**KIRKLEES METROPOLITAN COUNCIL
INVESTMENT & REGENERATION SERVICE**

**DELEGATED DECISION TO DETERMINE APPLICATIONS FOR
CONSENT, AGREEMENT OR APPROVAL REQUIRED BY CONDITION**

Reference No: 2021/44/92009/W

Site Address: Union Mills, Tanyard Road, Milnsbridge, Huddersfield, HD3 4NB

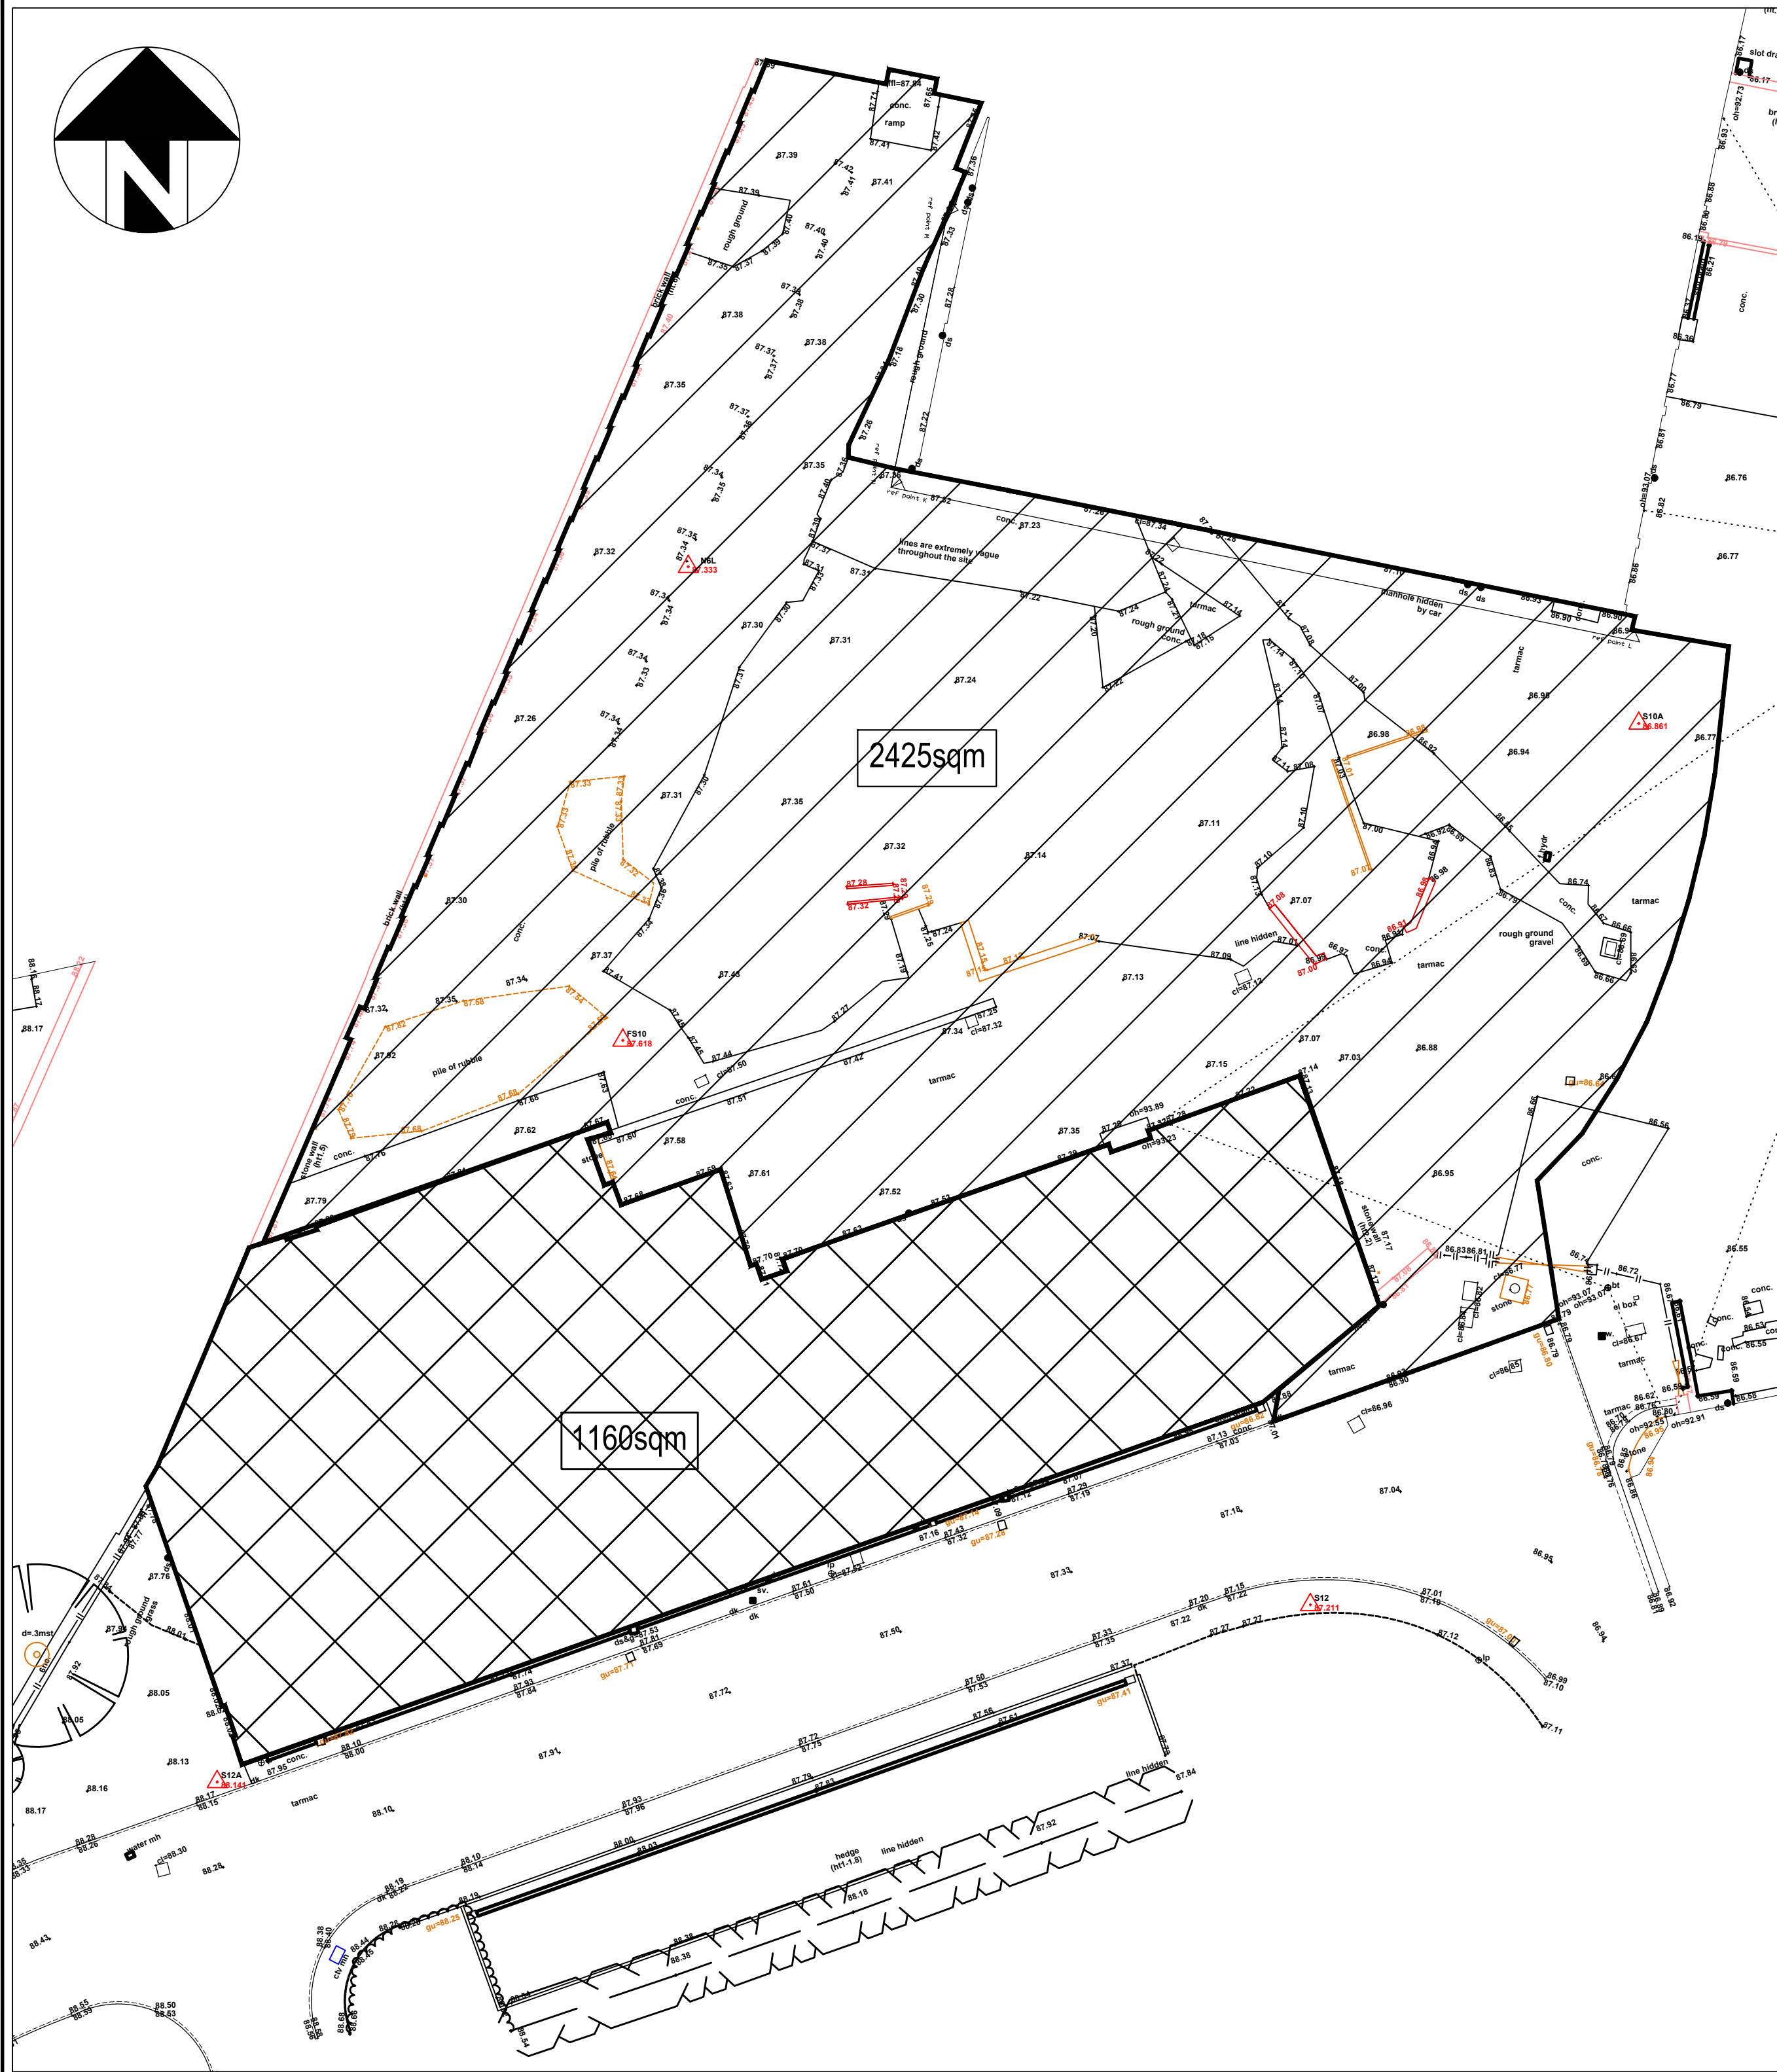
The proposed allowable discharge rate of 18 l/s and storage volume of 40m³ is acceptable. However, the use of a geocell type tank has not been justified and is not accepted at this time.

Geocell type tank cannot be easily inspected or maintained, and potentially could fail due to creep/failure of membrane over time with an overall low lifetime expectancy. Alternative methods of storage provisions, such as oversized pipes or concrete box type tanks, should be considered and the developer should assess these options. A maintenance regime for the surface water drainage system and details of who will be responsible for the long-term maintenance should be provided. These will require securing with a S106 agreement.

Ref: drawing no. (100)50 rev A : CAR CHARGING POINTS PUBLIC OPEN SPACE (POS) & LANDSCAPING DETAILS May 2021

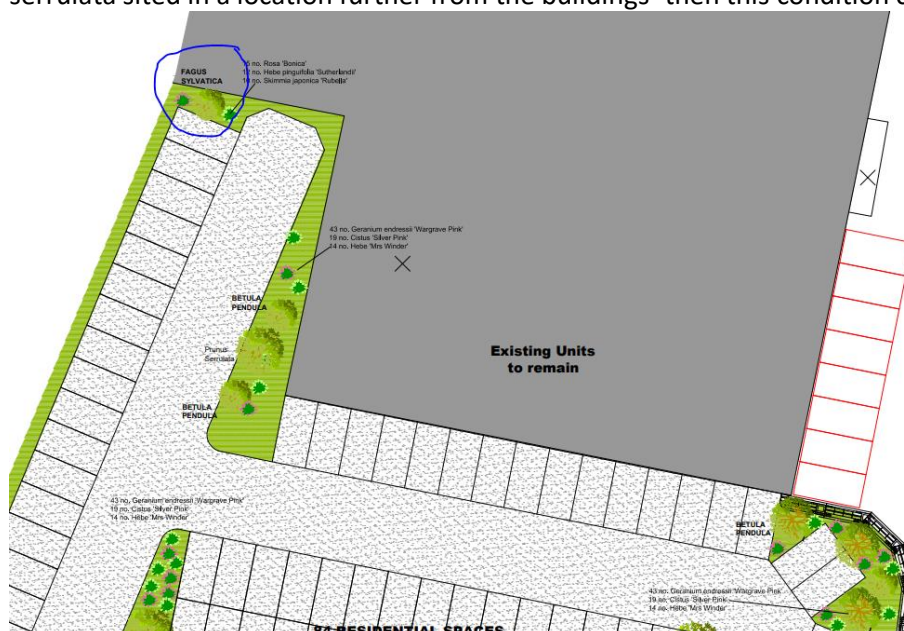
This condition was requested by K.C. Landscape. They have stated that a particular species, *fagus sylvatica*, is too close to neighbouring units (north-east of the site) and must be moved away. They suggest its location is swapped with the proposed *prunus serrulate* elsewhere within the site.
